**WEST SUSSEX COUNTY COUNCIL  
PRE APPLICATION CONSULTATION**

**SUBJECT: EG/57/16/PL**

**DESCRIPTION: Medical centre with pharmacy retail unit & other ancillary uses together with access onto Barnham Road & associated car parking. This application is a Departure from the Development Plan. – Revised Highways Informaiton**

**SITE: Land adjacent to the Croft Practice, Barhnam Road, Eastergate, PO20 3RP**

(Drawing 2016-2889-DWG-203)

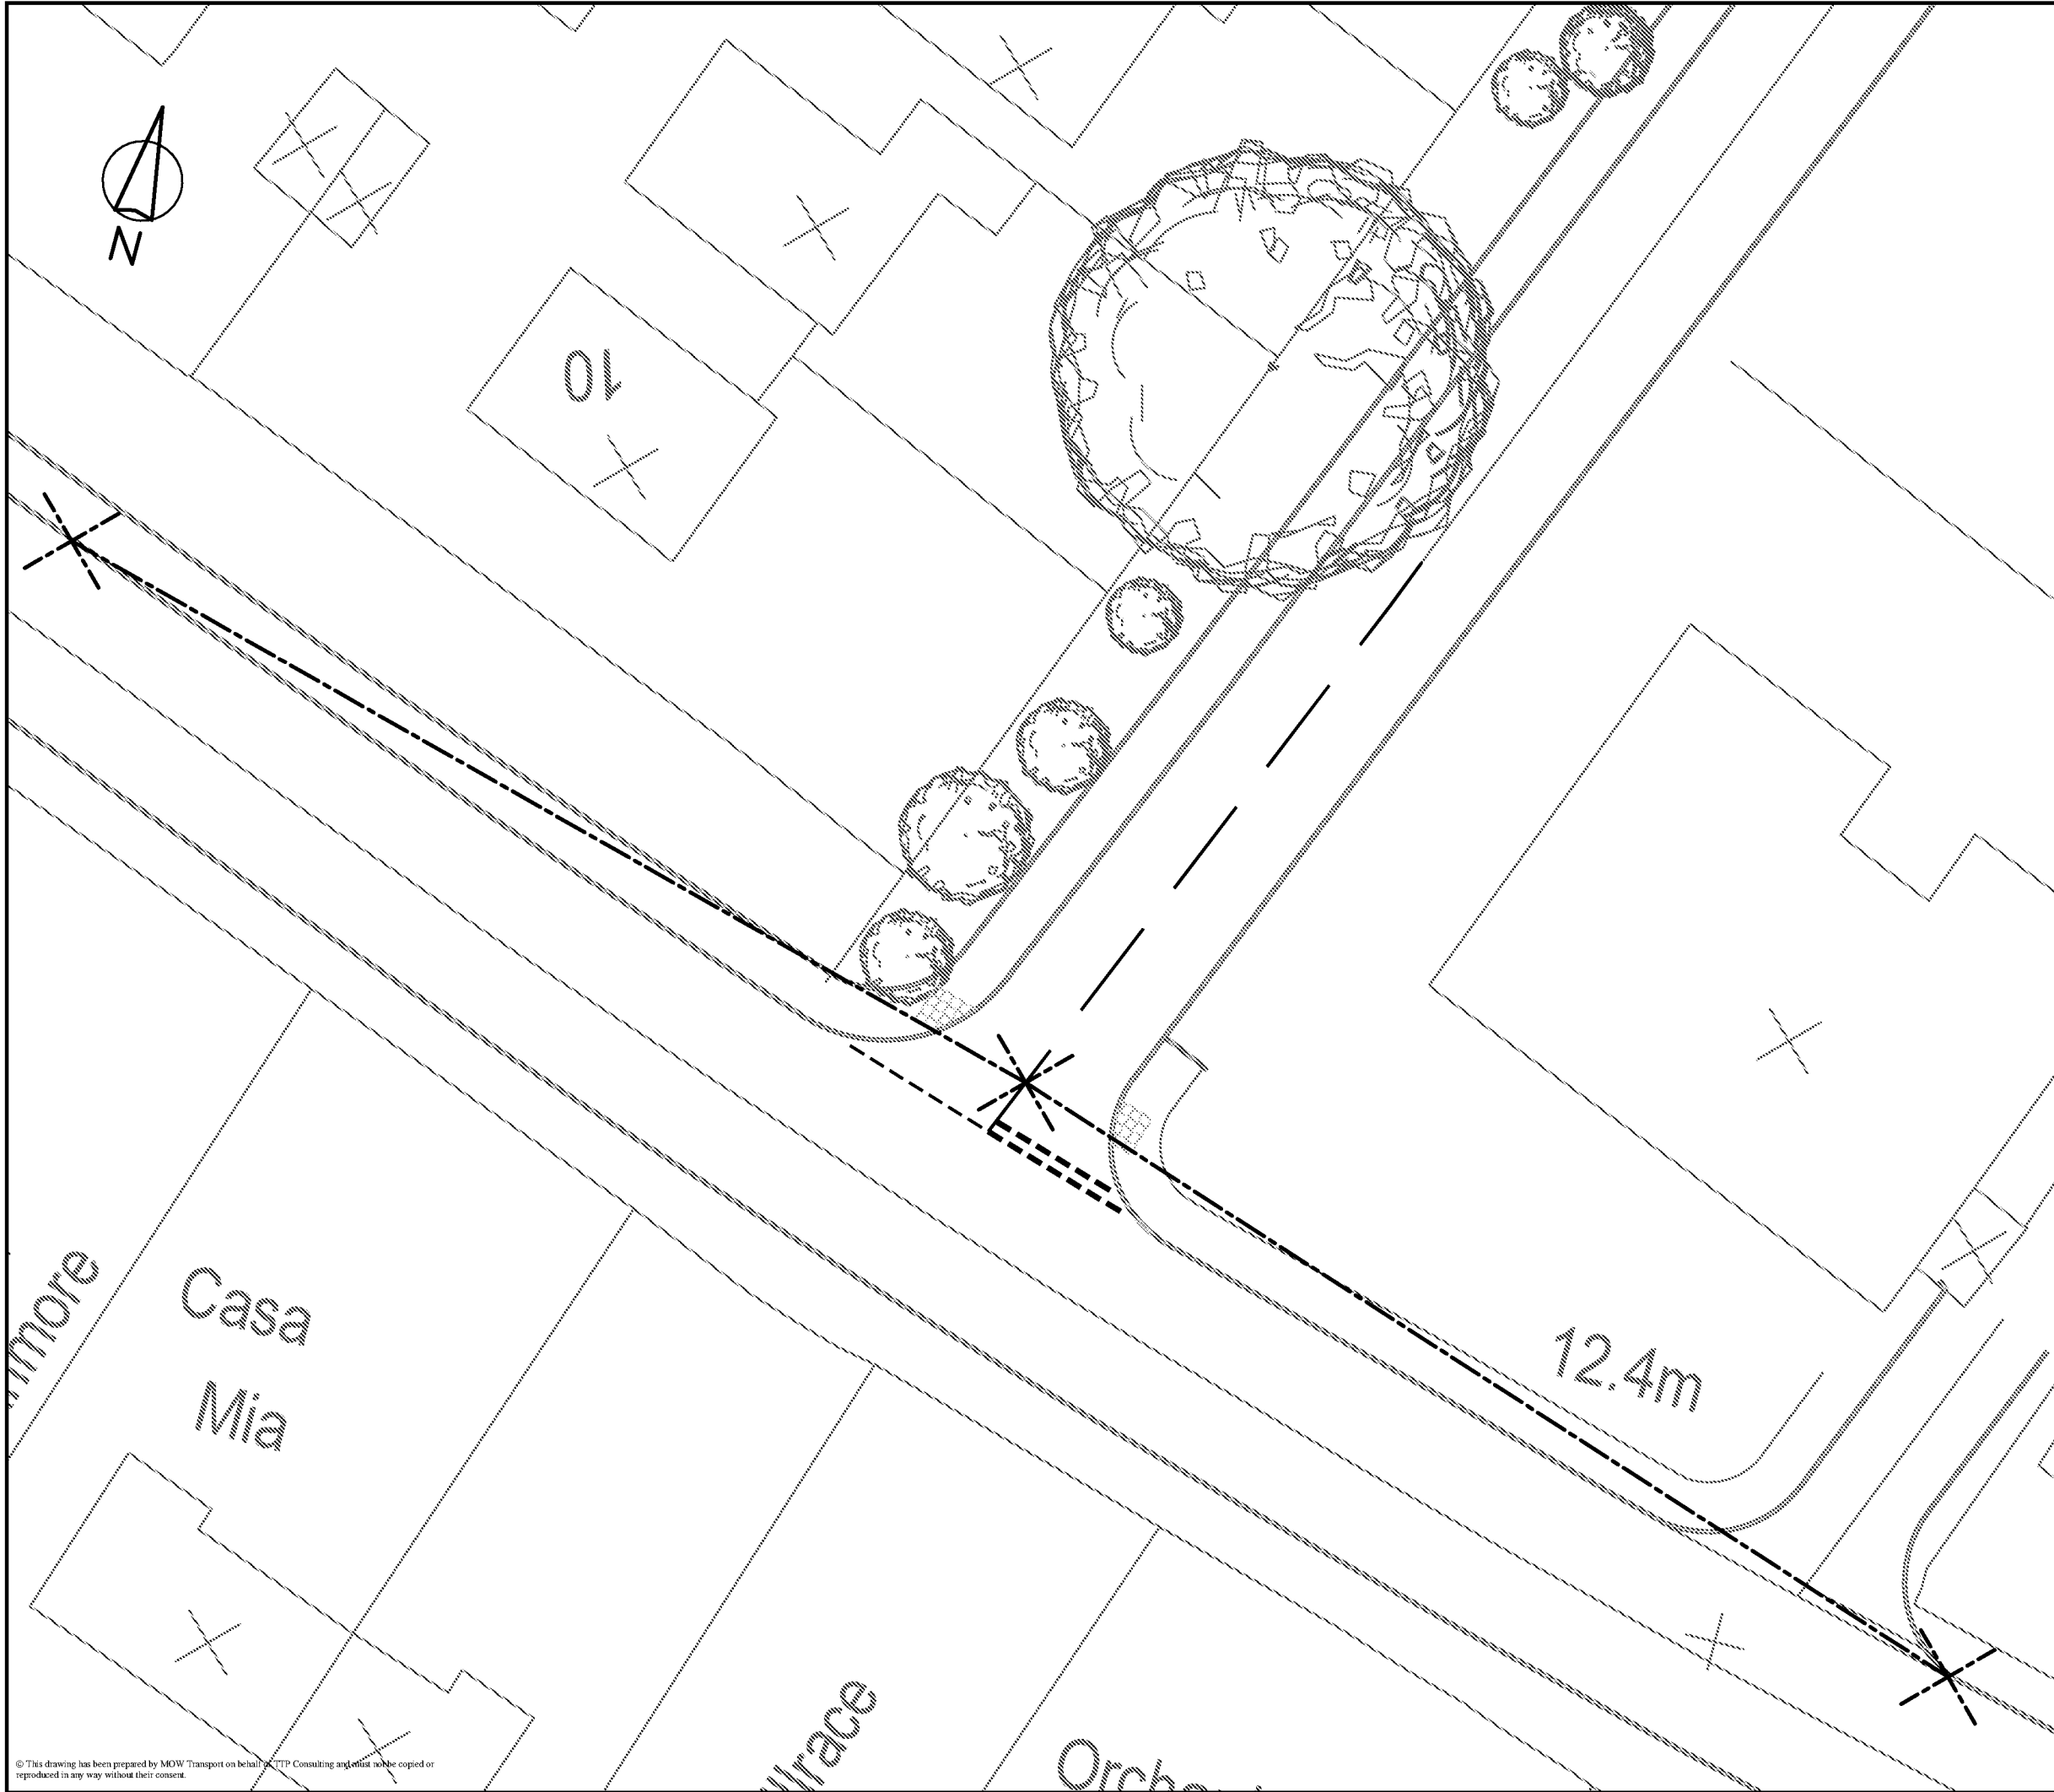
Drawing 2016-2889-DWG-203 demonstrates visability in line with current standards, the LHA would rasiie no concerns to visibility. This plan also demonstrates access arranegments and how the footways would link into the existing footway network.

No development shall commence until the vehicular access serving the development has been constructed in accordance with the approved planning drawing (Drawing no: 2016-2889-DWG-203).

No part of the development shall be first occupied until visibility splays of 2.4 metres by 43 metres have been provided at the proposed site vehicular access onto Barnham Road in accordance with the approved planning drawings (Drawing no: 2016-2889-DWG-203). Once provided the splays shall thereafter be maintained and kept free of all obstructions over a height of 0.6 metre above adjoining carriageway level or as otherwise agreed.

SITE PLAN SCALE 1:200

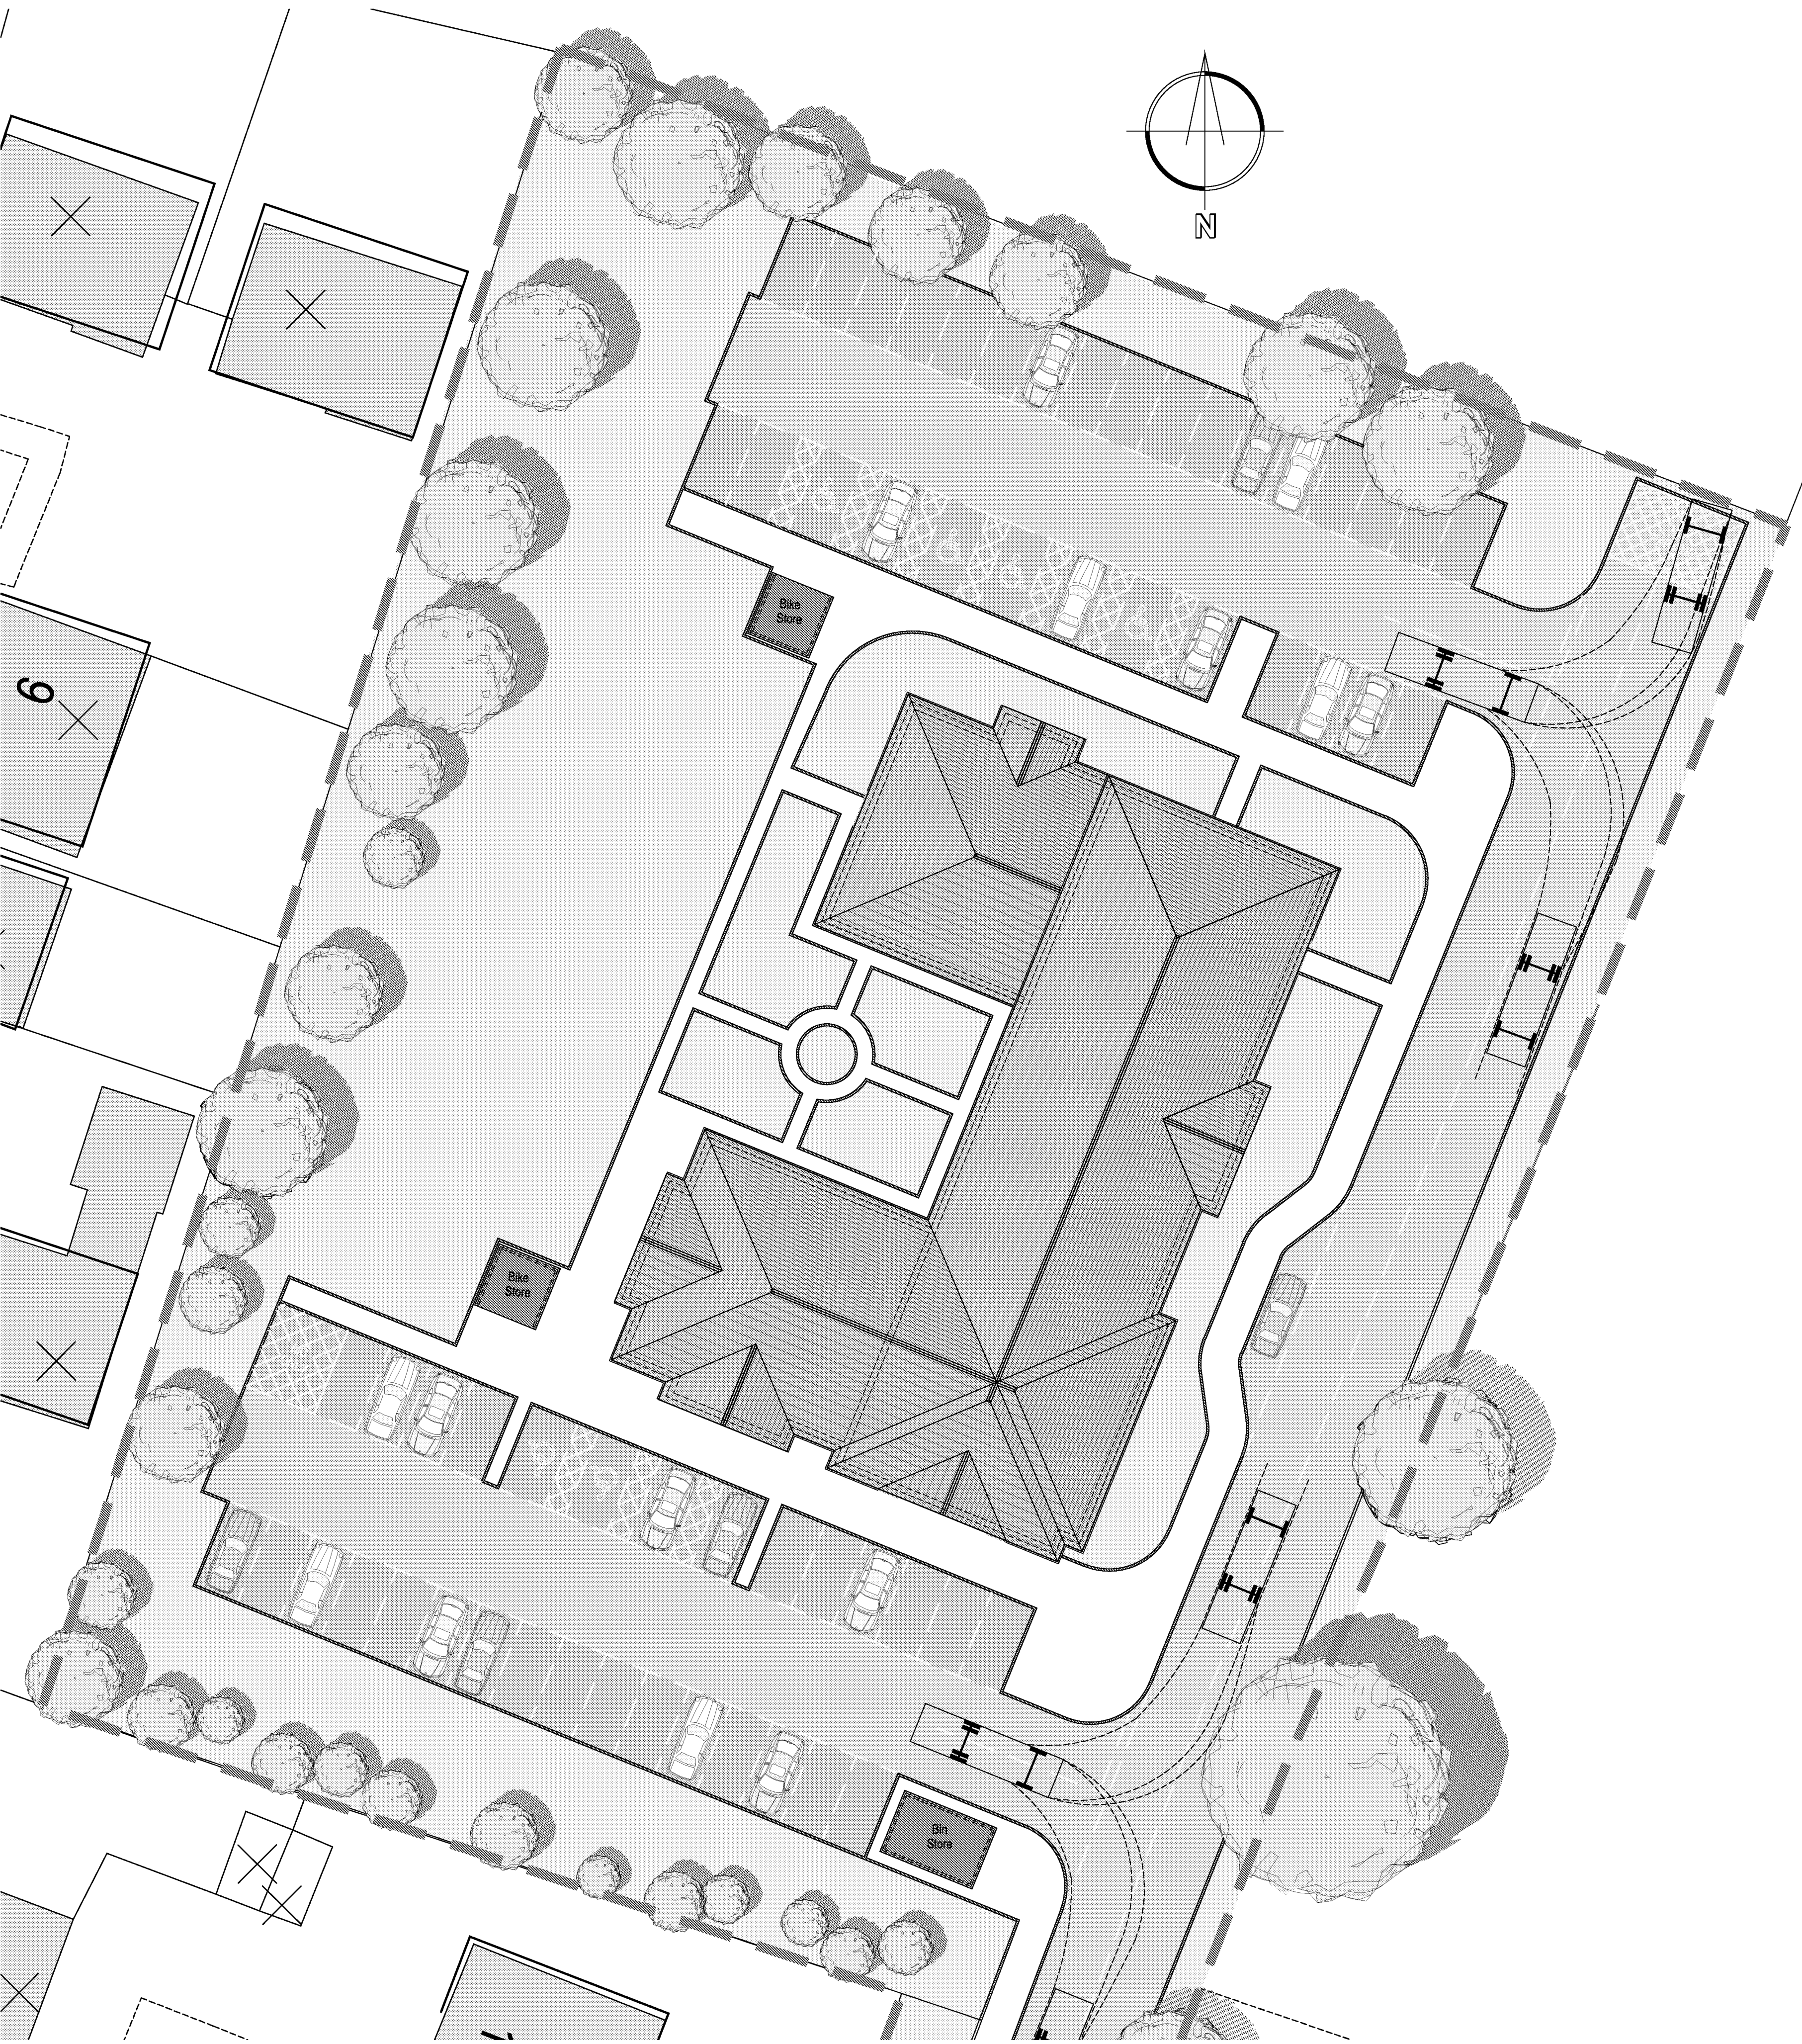
The LHA have been in discussion with the Transport Consultant in relation to the on site parking provision. After discussions parking has been increased from 54 – 60 spaces. The LHA are satisfied that although the maximum parking standard of 67 spaces has not been met the provision has been increased. Given the nature of the site with fixed appointment times and vehicles staying for short periods the LHA would not expect parking to cause a highway safety issue. The LHA can only consider the impact of overspill parking from a safety perspective; matters of amenity would be a matter for the consideration of the Local Planning Authority (LPA).

No part of the development shall be first occupied until the car parking has been constructed in accordance with the approved site plan. These spaces shall thereafter be retained at all times for their designated purpose.
